Boston Alternative Energy Facility

Statement of Common Ground between Alternative Use Boston Projects Limited and the Environment Agency

Planning Inspectorate Reference Number: EN010095

Date: October 2021

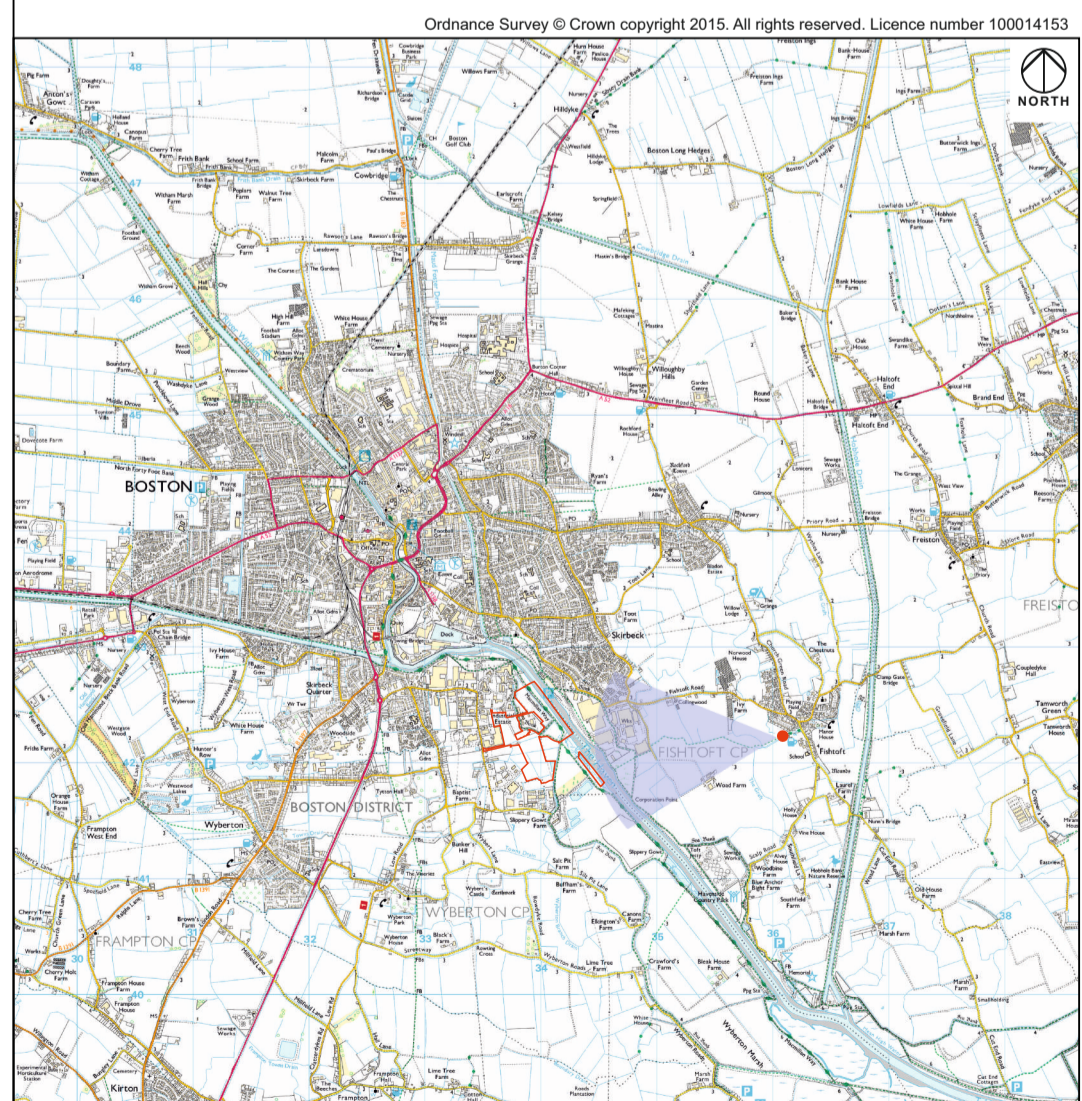
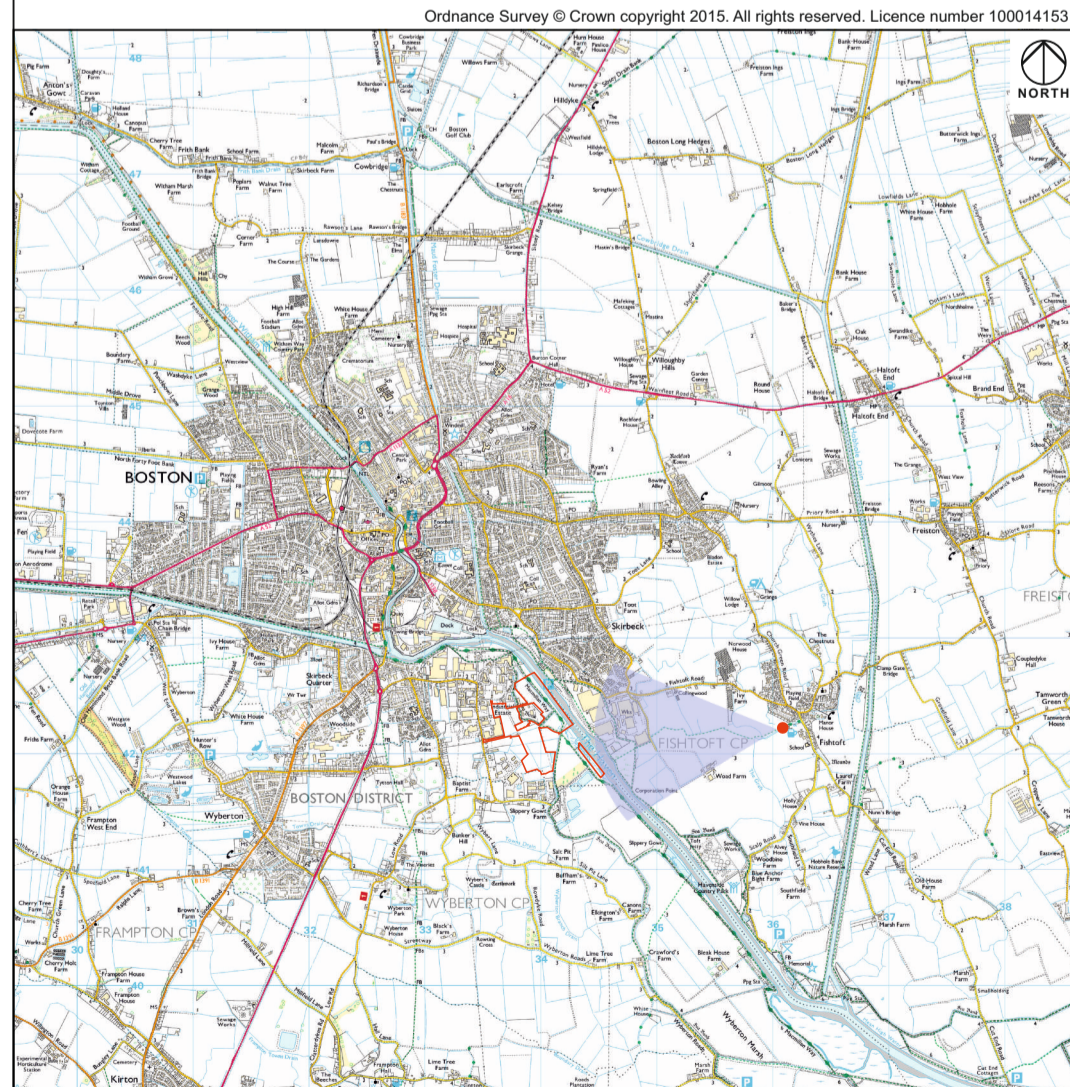
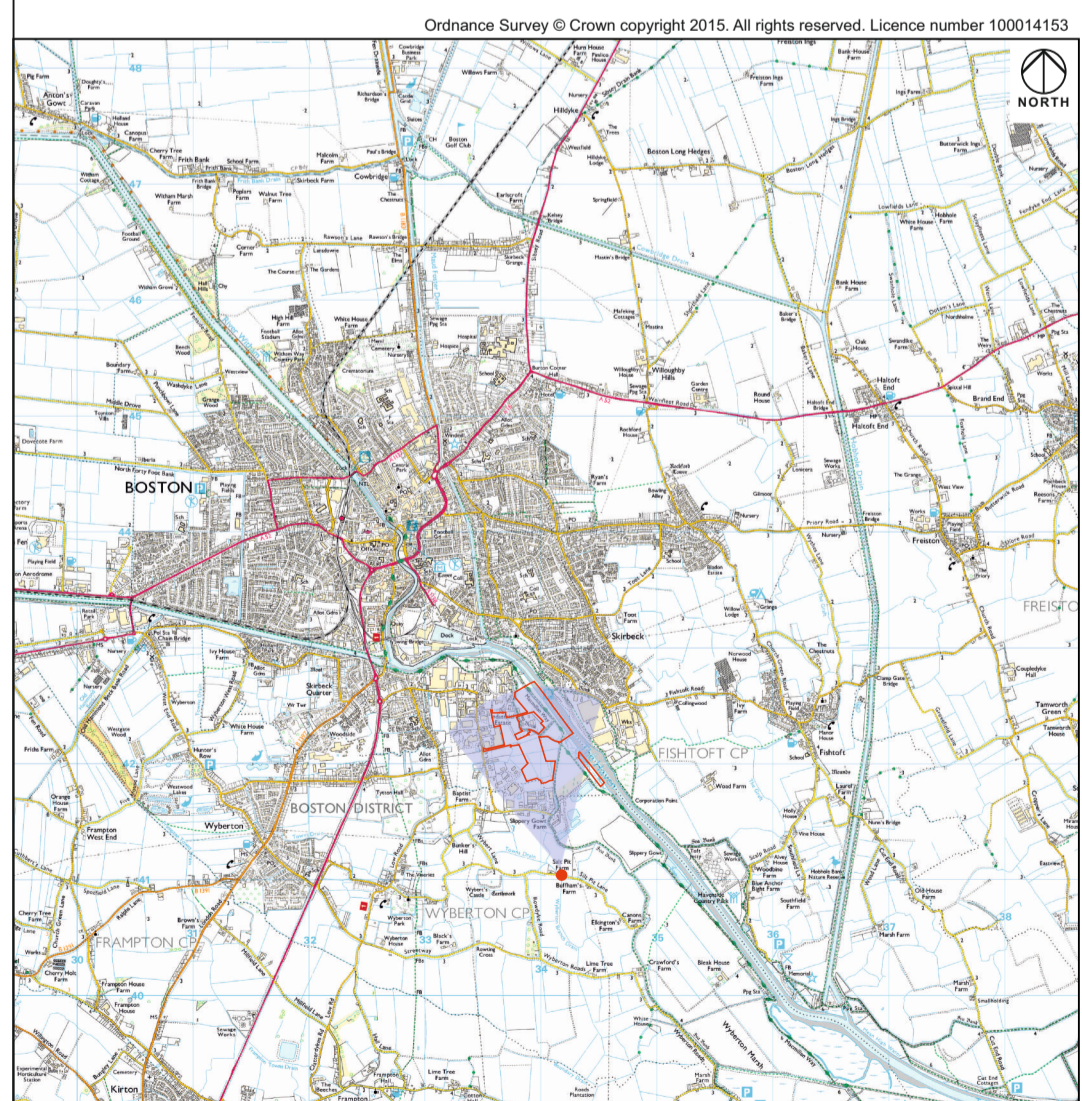
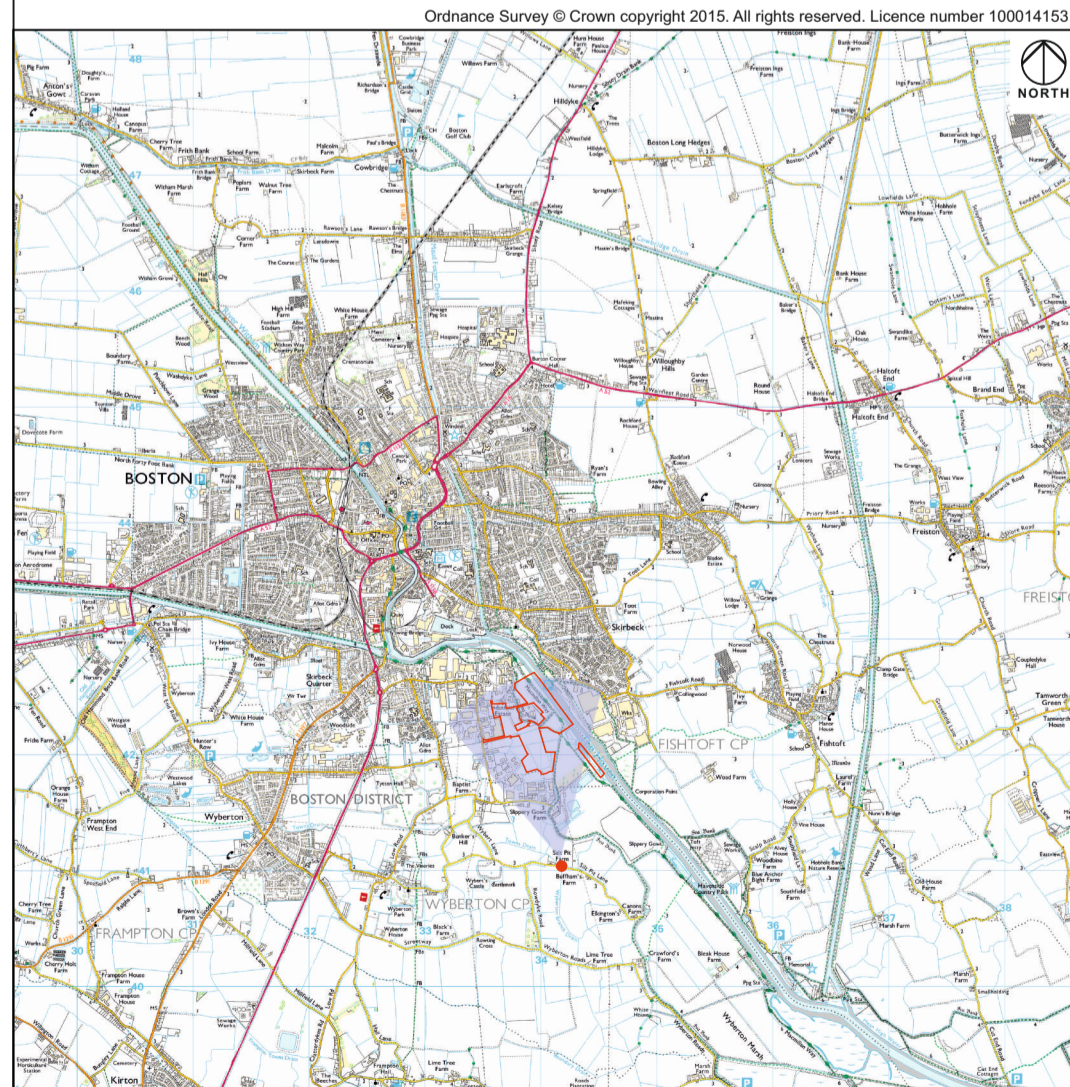
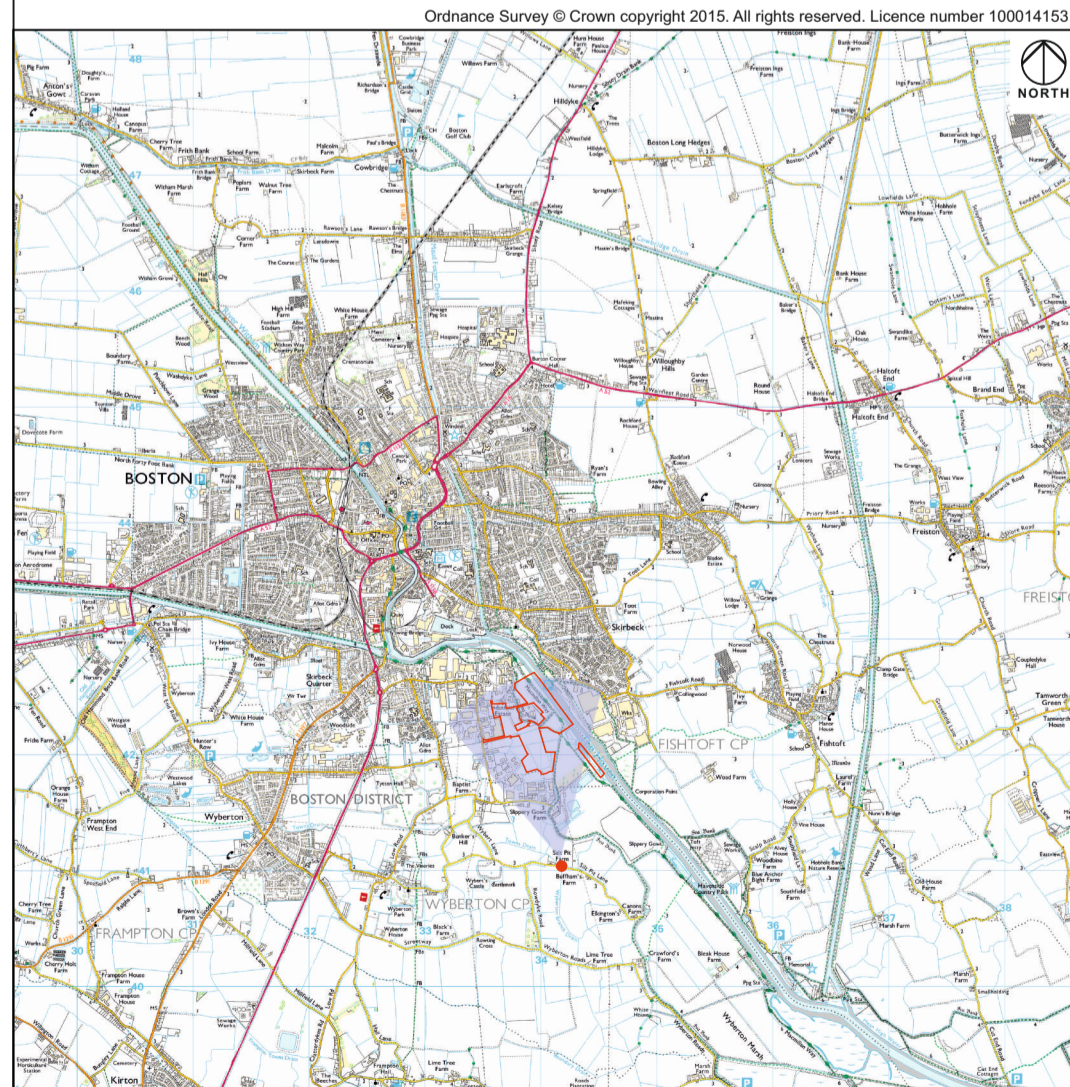
9.0 Landscape and Visual Impact Assessment					
EA 9.1	Chapter 9 Landscape and Visual Impact Assessment (document reference 6.2.9, APP-047)	Landscape and visual impact assessment	<p>The EA notes further information is needed on visible plumes.</p> <p>The EA notes a large visual impact on the landscape.</p>	<p>A technical note is being produced to address visible plumes, this will be provided to the EA.</p> <p>The LVIA identifies significant, irreversible adverse visual effects upon certain visual receptors. Effects upon wider landscape character from visible plumes are lessened due to the existing baseline and presence of industrial and infrastructure features.</p>	Under discussion
